From: Hornby, Mark [Mark.Hornby@lancashire.gov.uk]
Sent: 17 April 2012 16:26
To: Graeme Thorpe
Cc: ENV EPP Customer Service Area East
Subject: FW: Consultation on planning application 3/2012/0187 land at Lynbrook, Longsight Road, Clayton le Dale

detail of
visibility splay

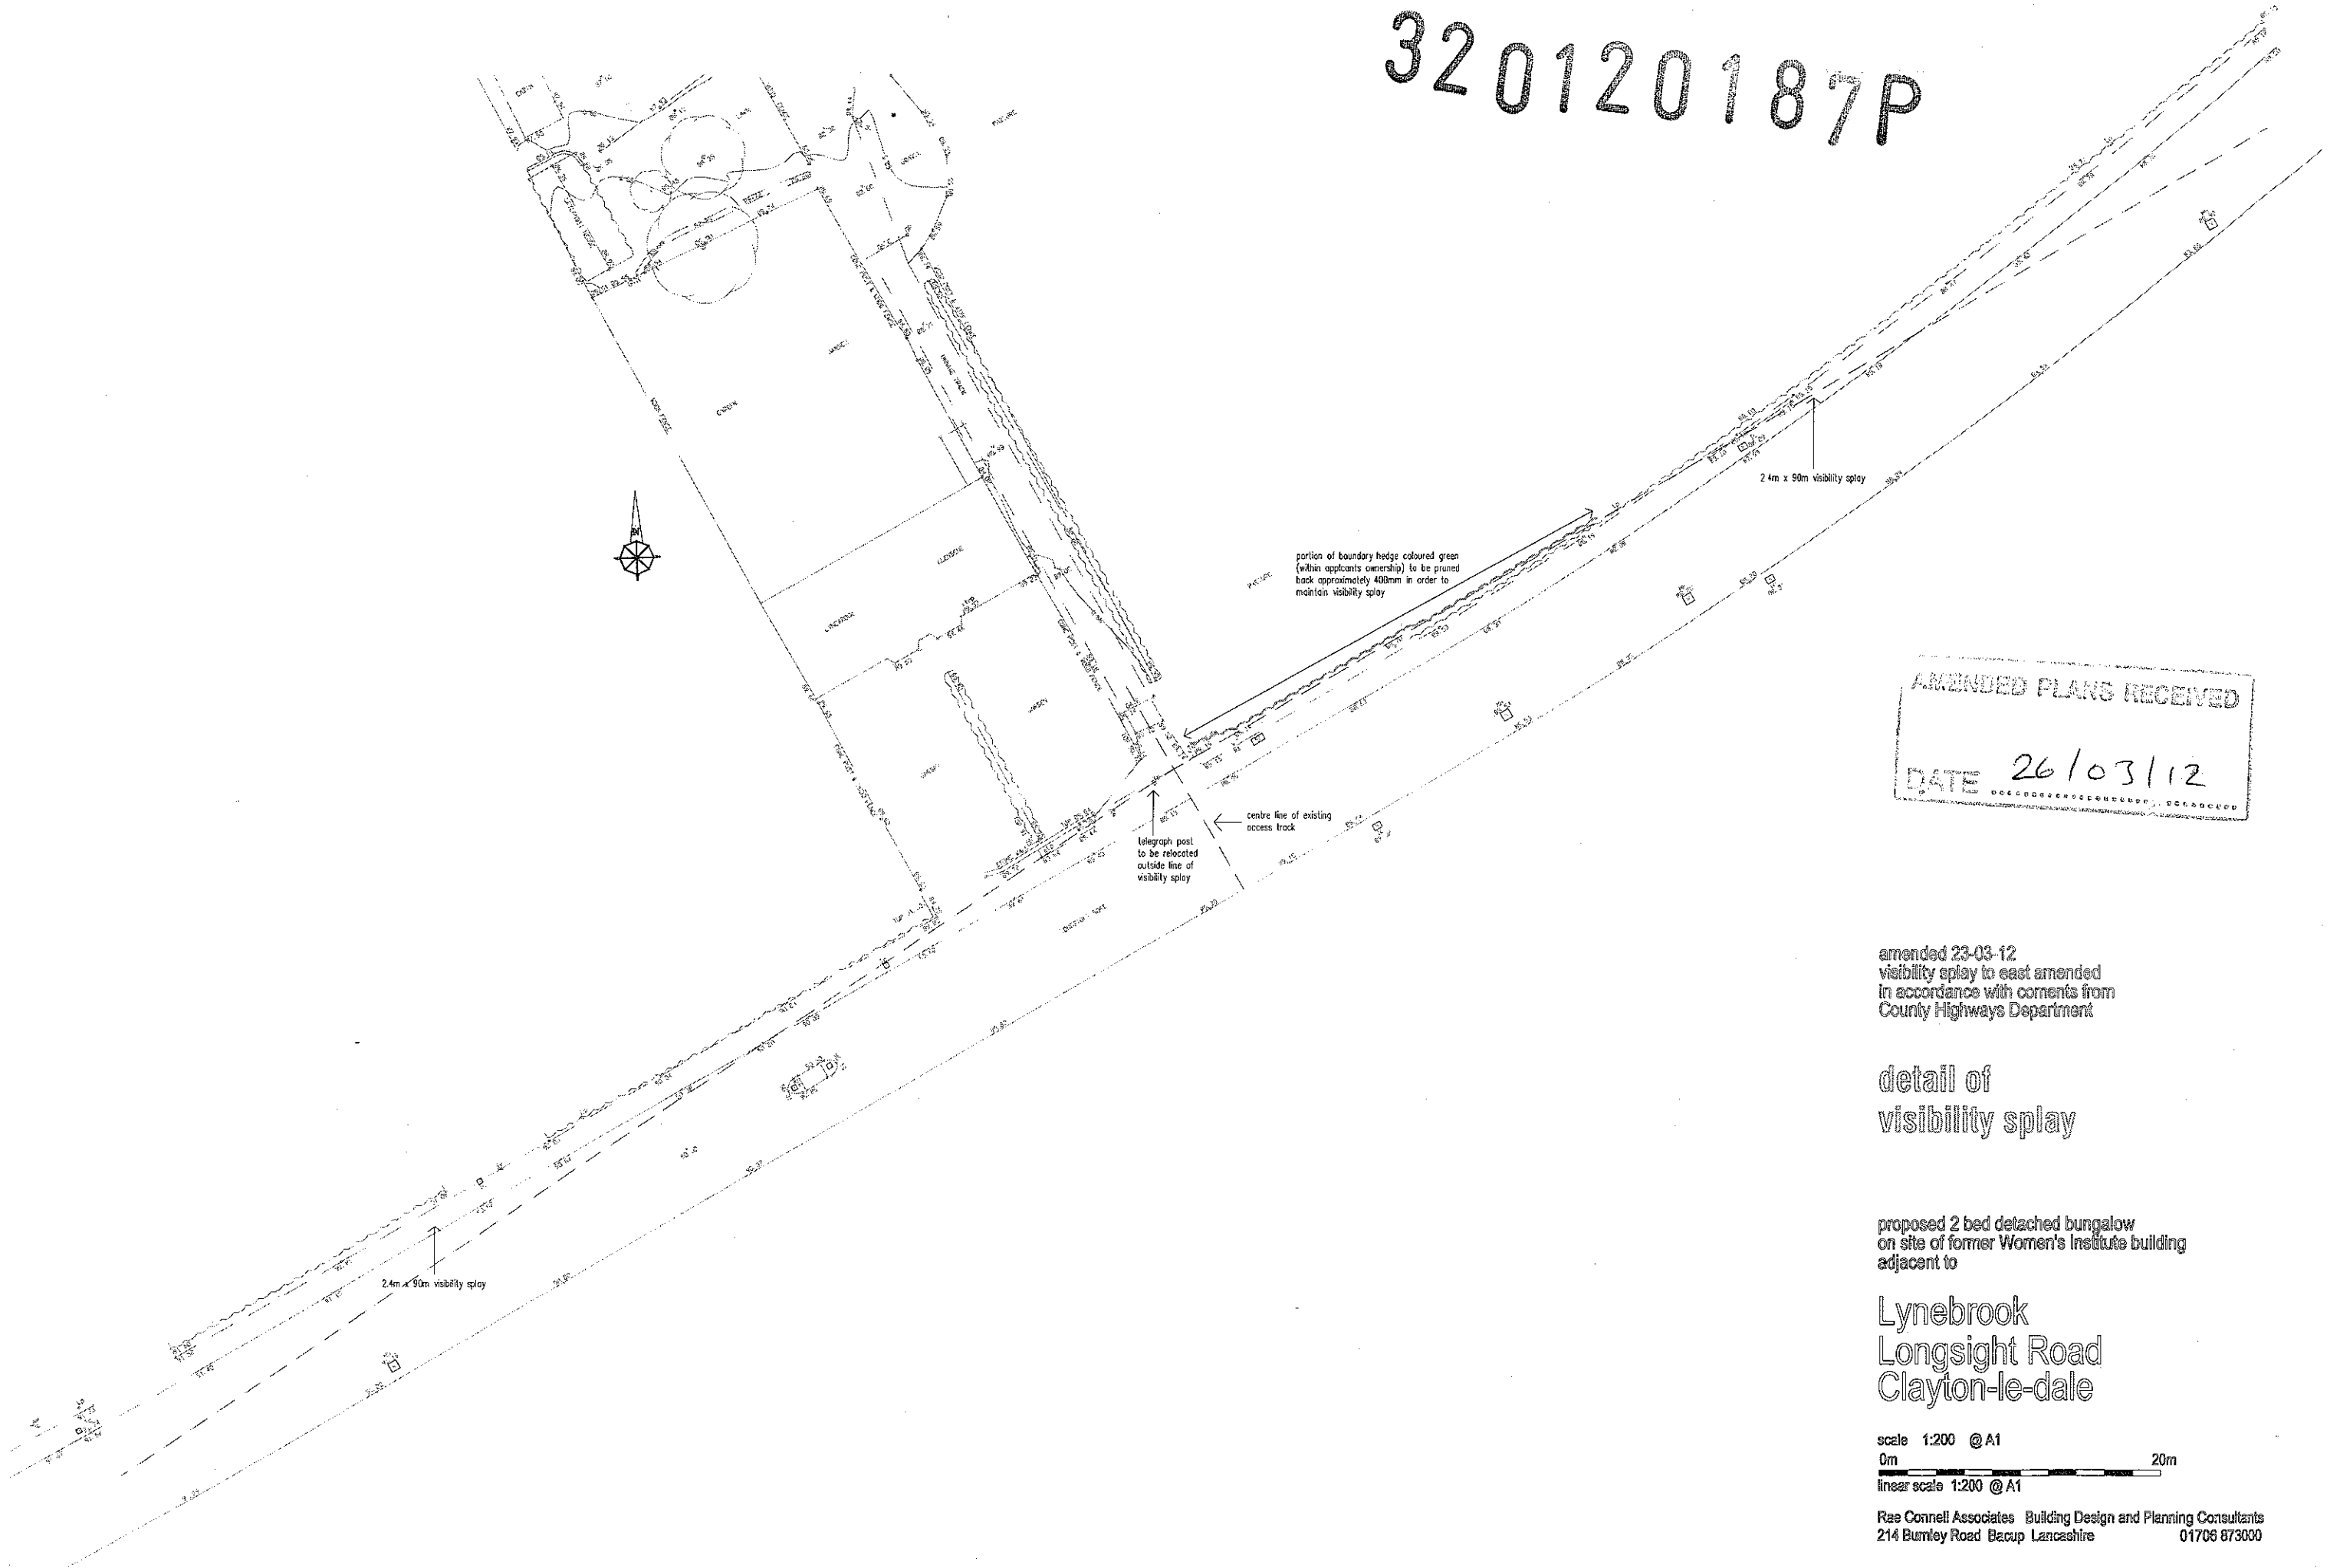
I am satisfied that an adequate visibility splay can be provided at the proposed access point, provided that the existing telegraph post adjacent to the driveway is moved back slightly and the hedgerow to the east is pruned back and kept suitably maintained. The proposed driveway already has the benefit of a dropped kerb and so no further engineering works will be required at the access to the highway.

The visibility splay to be the subject of this condition shall be that land in front of a line drawn from a point 2.4 metres measured along the centreline of the proposed driveway from the nearer edge of the carriageway of Longsight Road to points measured (a) 90 metres to the west along the nearer edge of the carriageway of Longsight Road and (b) 90 metres to the east along the centreline of the carriageway of Longsight Road, and shall be constructed and maintained at verge/footway level in accordance with a scheme to be agreed by the Local Planning Authority in conjunction with the Highway Authority. Reason: To ensure adequate visibility at the site access.
